Reference No:	2024/44/91996/W
Site Address:	Land at, Penistone Road, Fenay Bridge, Huddersfield, HD8 0AW
Description:	Discharge of details reserved by conditions 7 (Phasing Plan), 8 (Phase 1 SI), 9 (Phase 2 SI), 12 (Highway Condition Survey), 13 (CEMP), 14 (Construction Environmental Management Plan: Biodiversity), 16 (Trial Trenching) and 19 (Temporary Surface Water Management Plan) of previous permission 2022/93154 for erection of 68 dwellings with associated access, parking, open space, landscaping and infrastructure works (including installation of surface water attenuation tank)
Recommending Officer:	Katie Chew

Officer Report

Application: 2024/91996

Proposal: Discharge of details reserved by conditions 7 (Phasing Plan), 8 (Phase 1 SI), 9 (Phase 2 SI), 12 (Highway Condition Survey), 13 (CEMP), 14 (Construction Environmental Management Plan: Biodiversity), 16 (Trial Trenching) and 19 (Temporary Surface Water Management Plan) of previous permission 2022/93154 for erection of 68 dwellings with associated access, parking, open space, landscaping and infrastructure works (including installation of surface water attenuation tank).

- Phase #1 R&S Complete October 2024
- Phase #2 R&S Complete January 2025
- Phase #3 R&S Complete March 2025

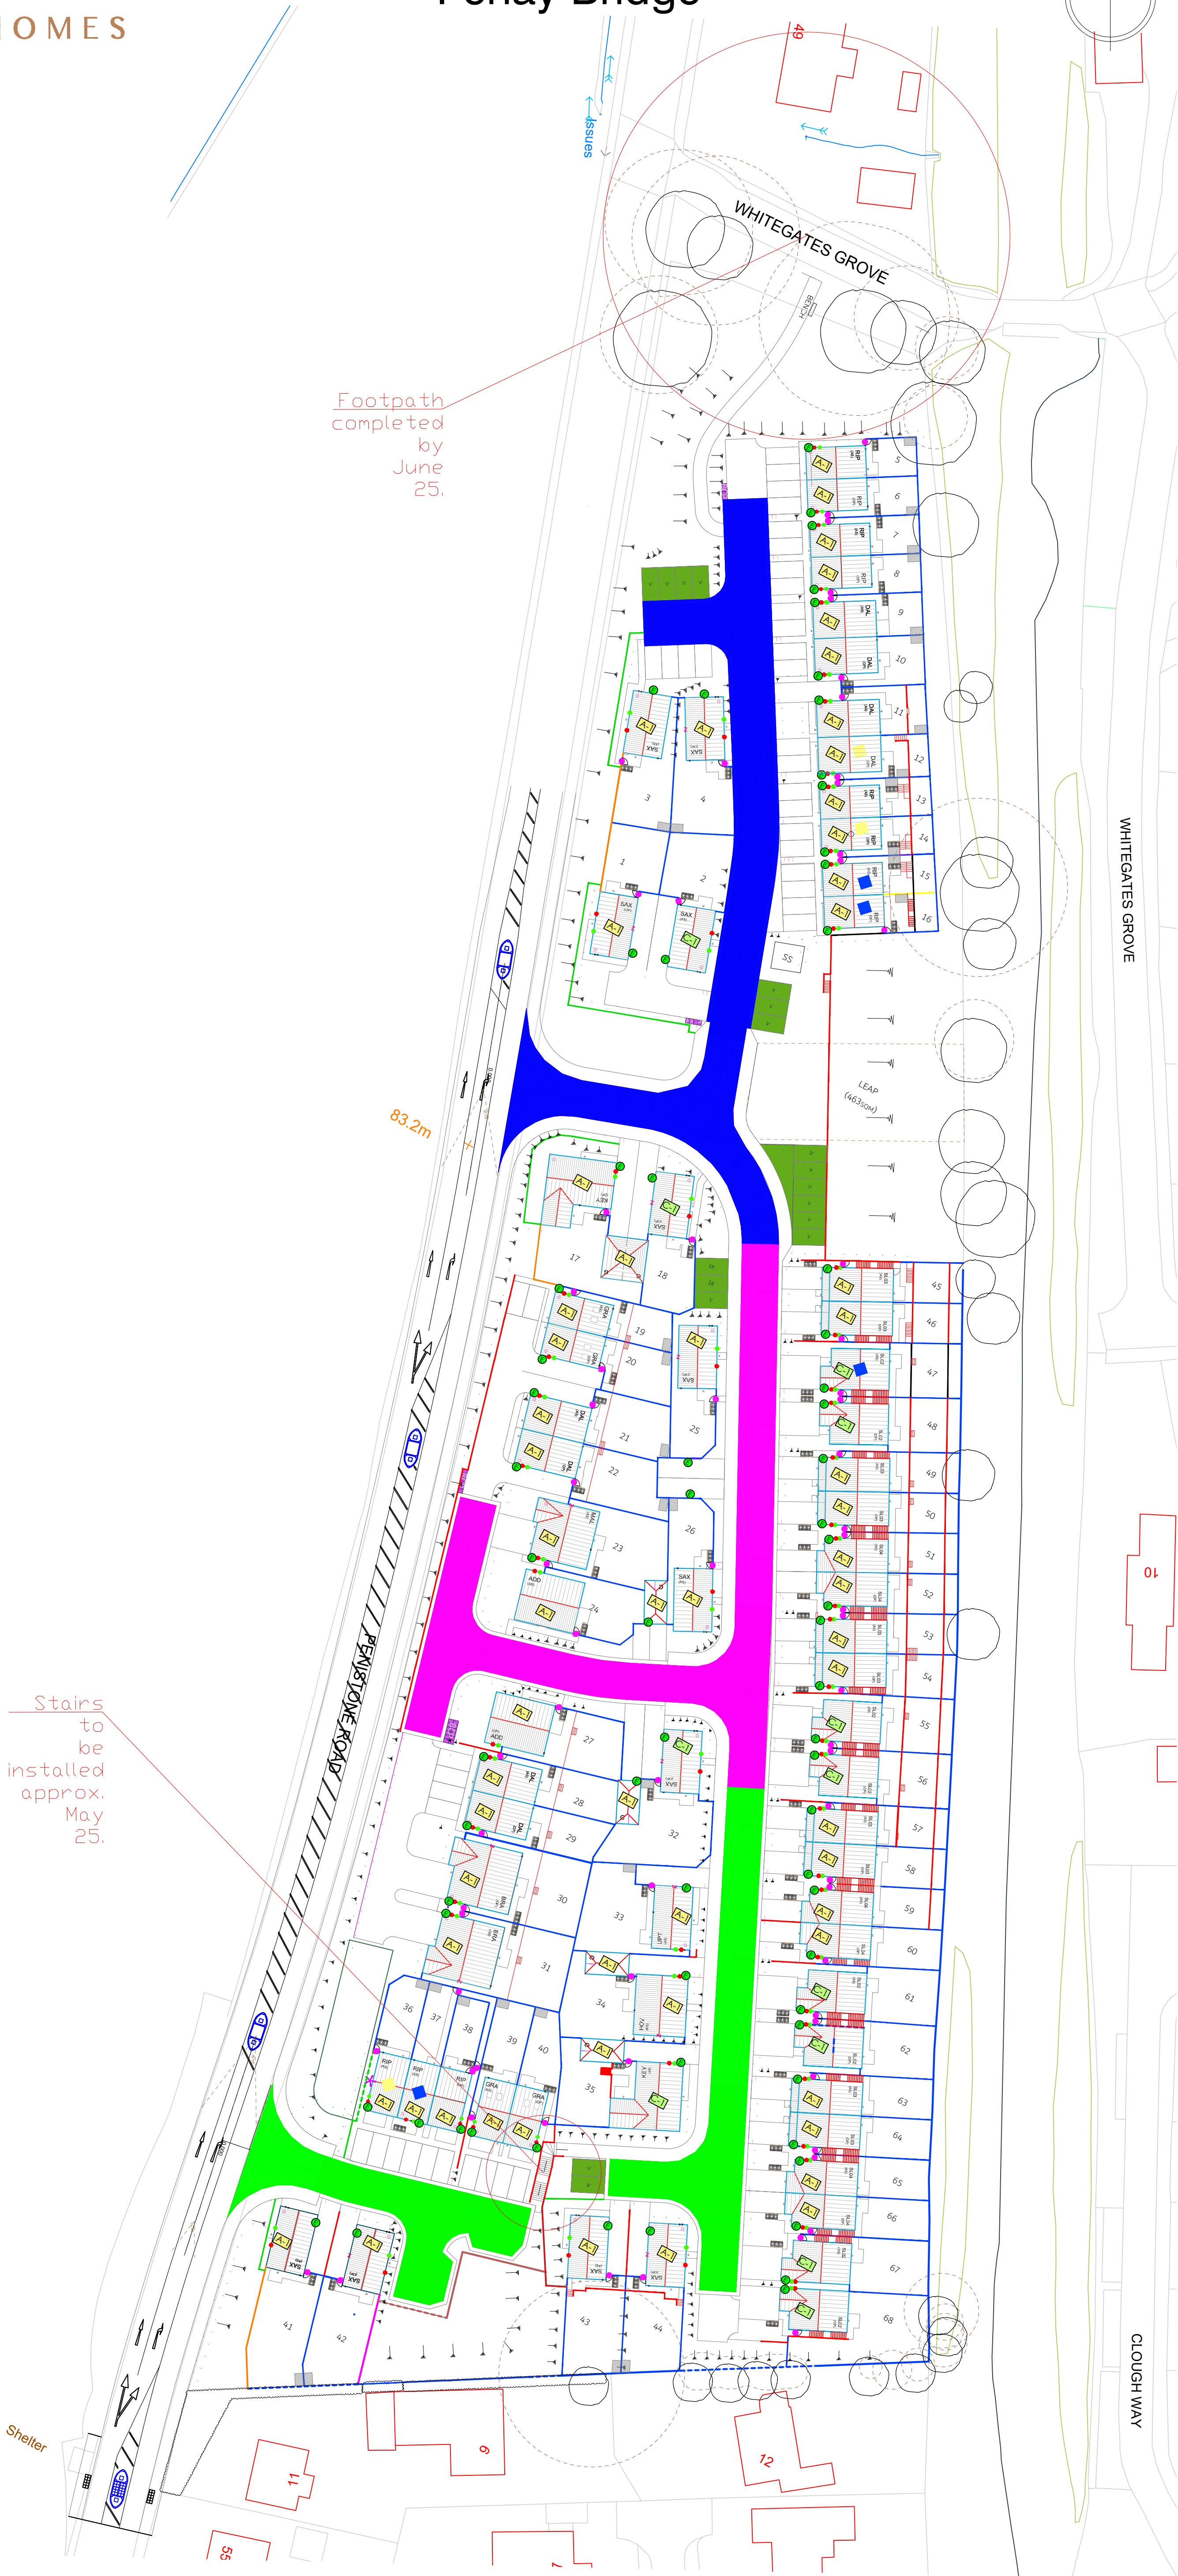
- Phasing Plan, Drawing No. Z078 – 004 Rev. B, received 06/11/2024.

The plan ref. Z078-004 rev. B has been submitted pursuant to condition 7. This document splits the site delivery into three phases, with a start date July 24 and end date of September 26.

Within this, the phasing plan sets out appropriate and reasonable delivery of the dwellings and the various bits of key infrastructure, as identified within the condition. This includes the attenuation tank being delivered prior to first occupation, roads (to base course) and sewers being provided to access dwellings as they're occupied, and the Public Open Space and connective footpaths (including the stairs) being delivered in parcels at reasonable intervals and when required.

Officers consider the submitted details to be acceptable and recommend that they be approved. However, as the condition has ongoing requirements it cannot be fully discharged at this time. A note setting out the ongoing requirements is recommended to be included on the decision notice.

Drawing No. Z078 - 004
Rev D

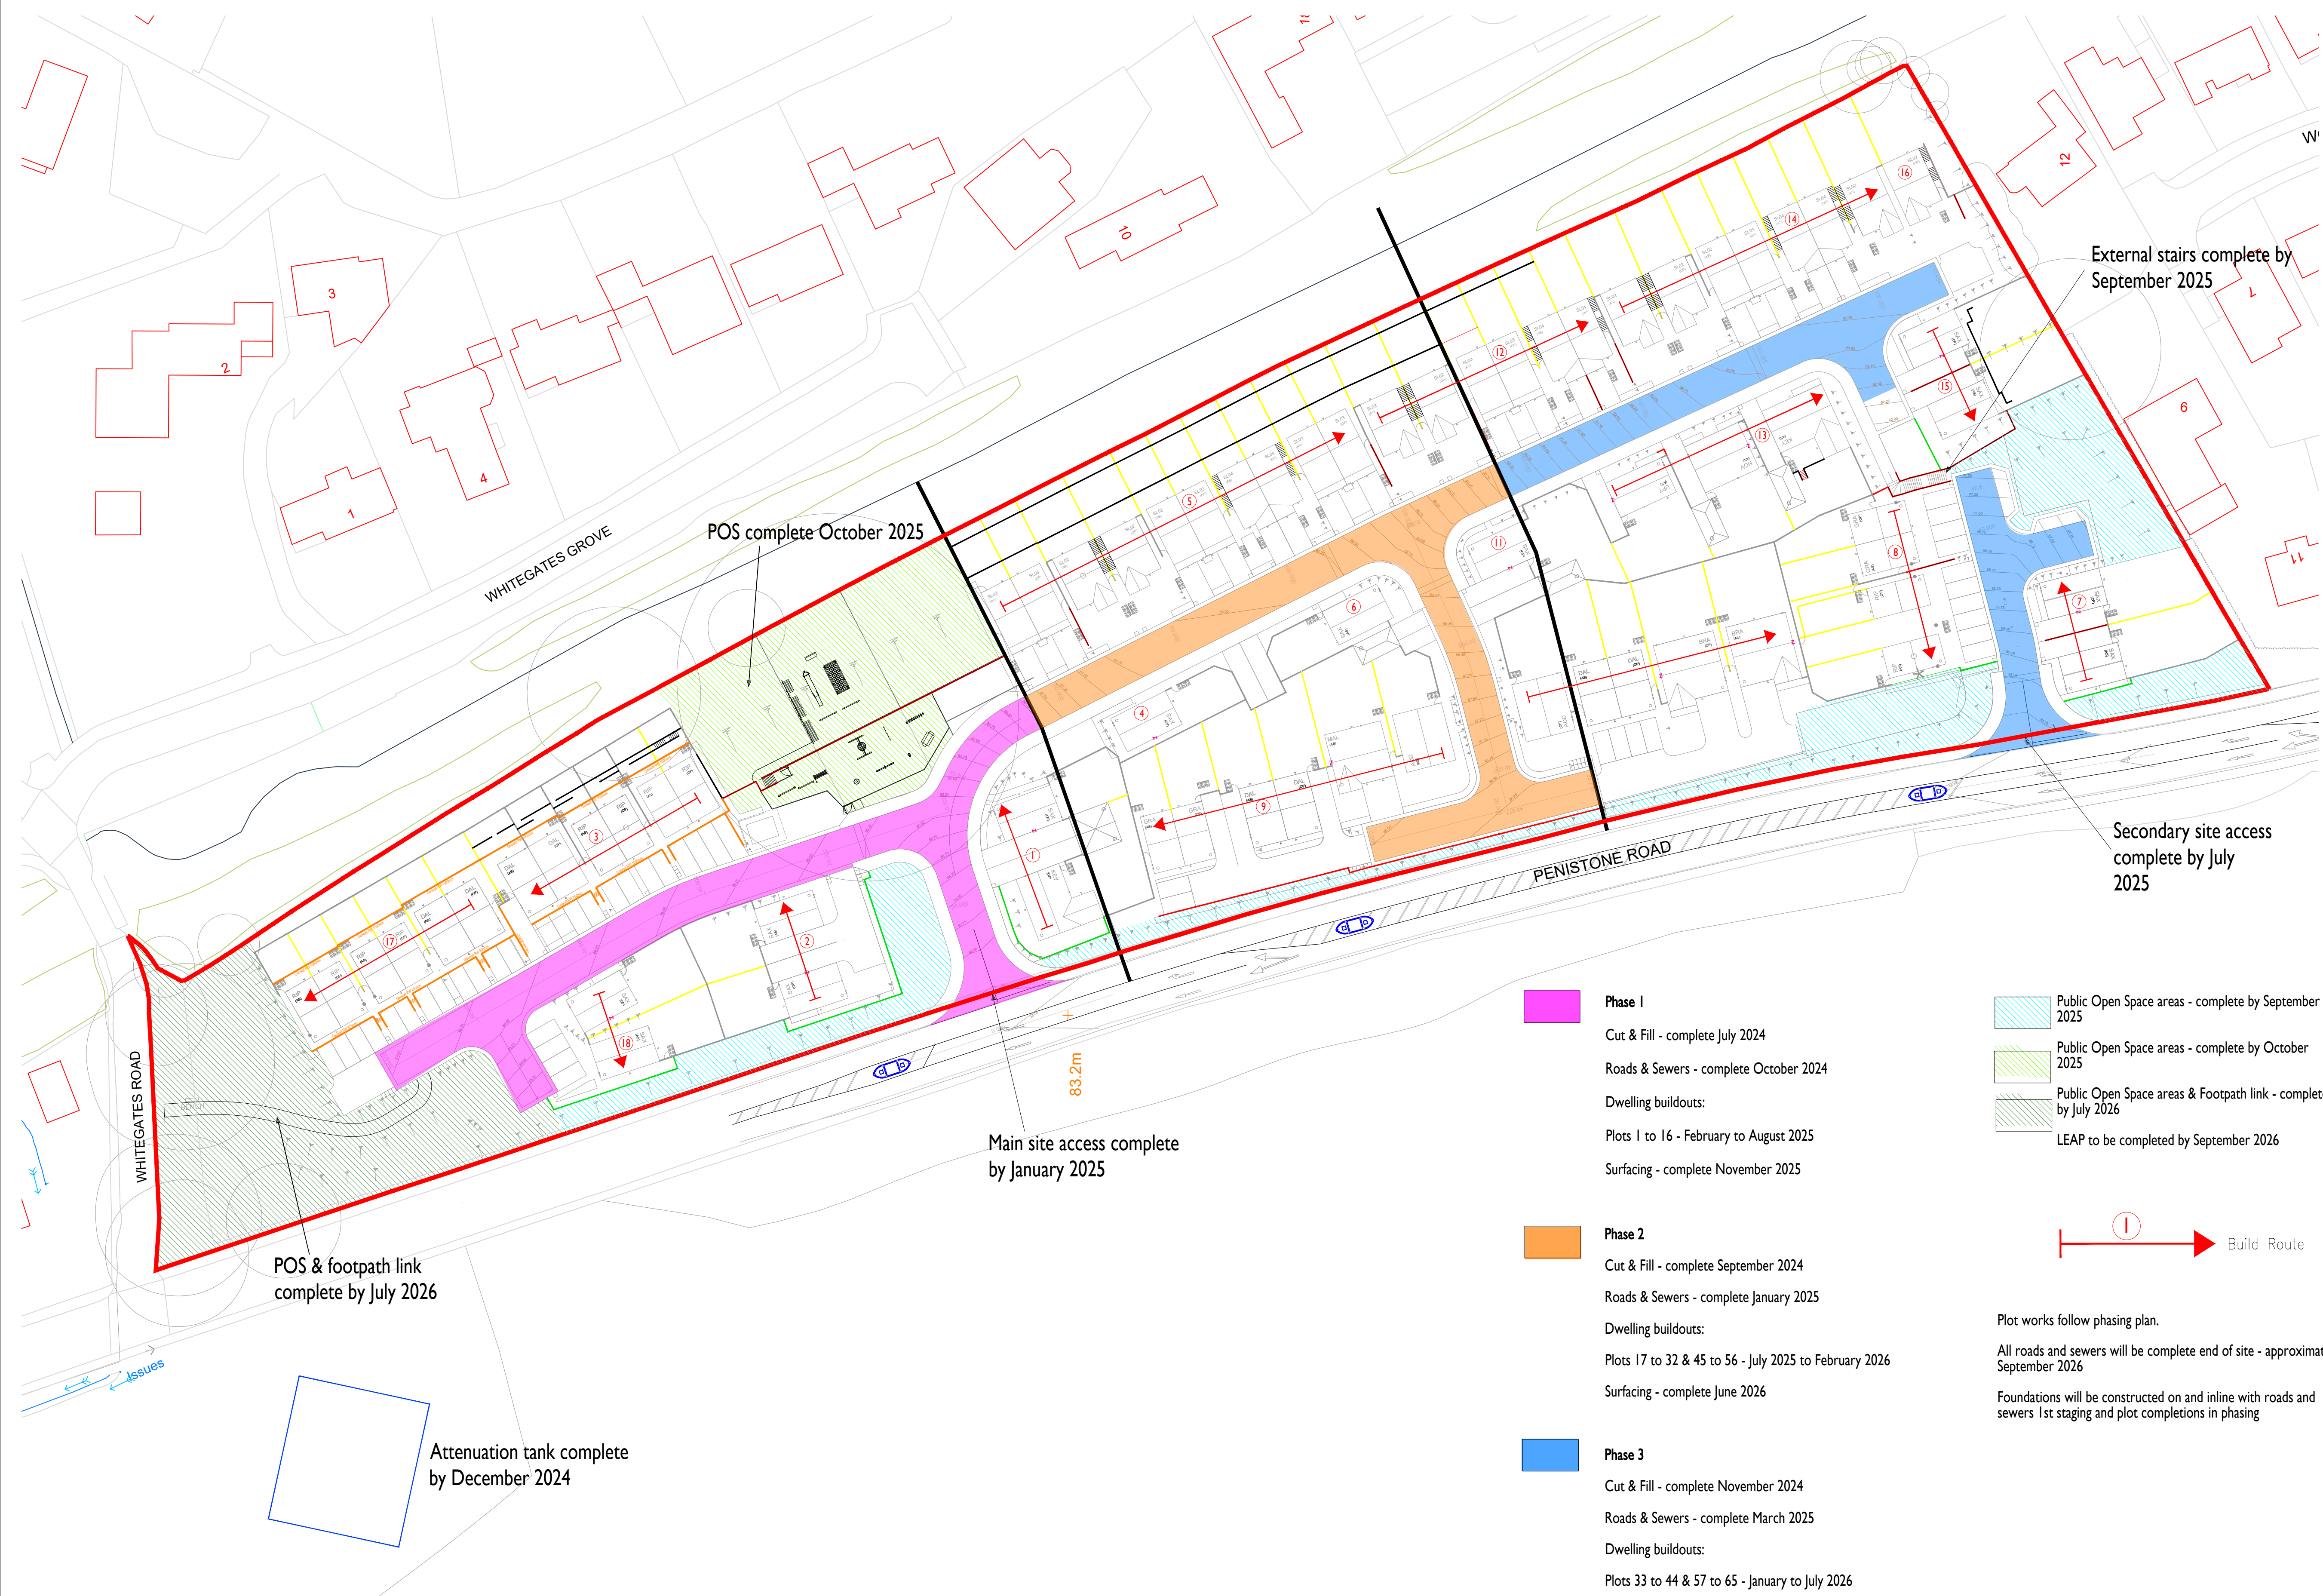
In terms of HGV waiting areas and their management, HGV waiting areas have been identified on the submitted Construction Management Plan (located within Phase 3 of the development) and these areas are to be managed by a site banksman accordingly.

Paragraph 5.19 of the submitted CEMP outlines that on-site staff parking is provided in the 20 no. allocated parking areas identified on the appended Construction Management Plan. With a total of 6 no. contractors expected on site at any one time.

A loading and unloading area is shown within the appended Construction Management Plan drawing. This is shown to be located within Phase 1 of the development, adjacent to the site access for construction during Phase 1 (White Gates Grove).

Paragraph 5.17 of the submitted CEMP notes that storage of all plant and materials are to be within the designated areas identified within the submitted Construction Management Plan. These areas are segregated with fencing and during out of operational hours, these fenced areas are to be secured to avoid access by unprohibited personnel.

The appended Construction Management Plan drawing does show 4 'stores' to be provided on site, these are located well away from adjacent neighbouring properties and therefore the above is considered to be acceptable.

Details of the signage erected are shown within the submitted Construction Management Plan (CMP) (drawing no. Z078-024 Rev F). The CMP shows the site entrance signage, which is considered to be relevant, visible and easy to interpret.
